From: Laura Gibbons
Sent: 09 July 2018 08:26
To: Planning.Responses
Subject: RE: Planning Consultation on: AL/59/18/HH

Engineers Comments Relating to Surface Water Drainage

APPLICATION **AL/59/18/HH**

Site Address: Northfields Hook Lane Aldingbourne PO20 3TE

Drawing 4 / 4

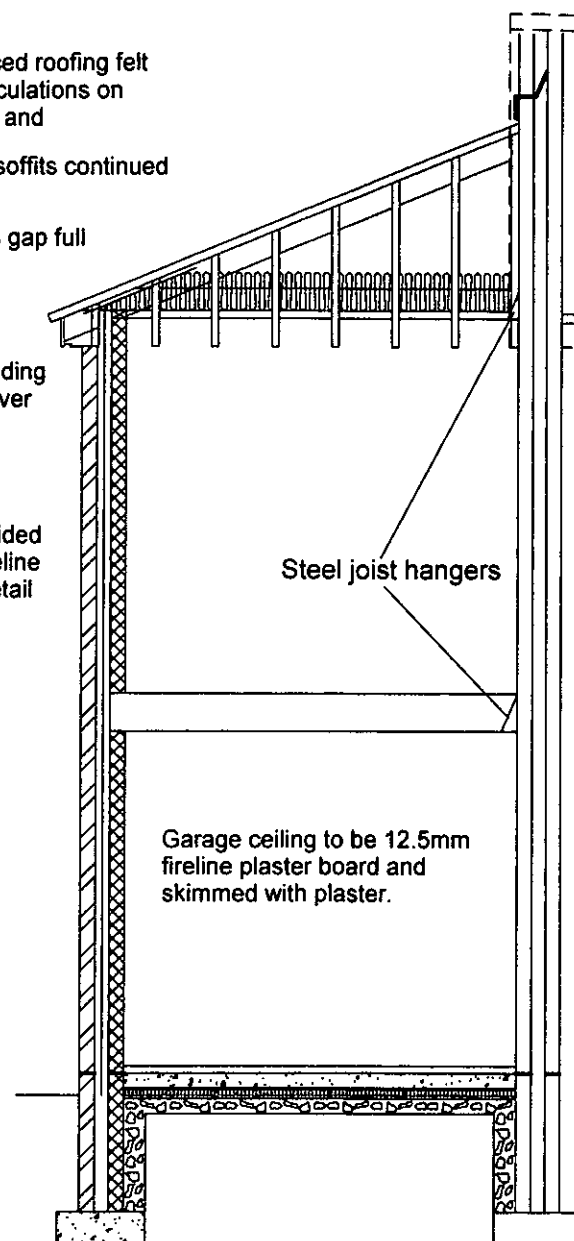
Please apply standard condition ENGD2B.
Soakaways must be investigated for surface water disposal.

Infiltration rates for soakage structures are to be based on percolation tests undertaken in the winter period and at the location and depth of the proposed structures. The percolation tests must be carried out in accordance with BRE 365, CIRIA R156 or a similar approved method and cater for the 1 in 10 year storm between the invert of the entry pipe to the soakaway, and the base of the structure. It must also have provision to ensure that there is capacity in the system to contain below ground level the 1 in 100 year event plus 40% on stored volumes, as an allowance for climate change. Adequate freeboard must be provided between the base of the soakaway structure and the highest recorded annual groundwater level identified in that location.

Any SuDS or soakaway design must include adequate groundwater monitoring data to determine the highest winter groundwater table in support of the design. The applicant is advised to discuss the extent of groundwater monitoring with the Council's Engineers. Supplementary guidance notes are also enclosed for information.
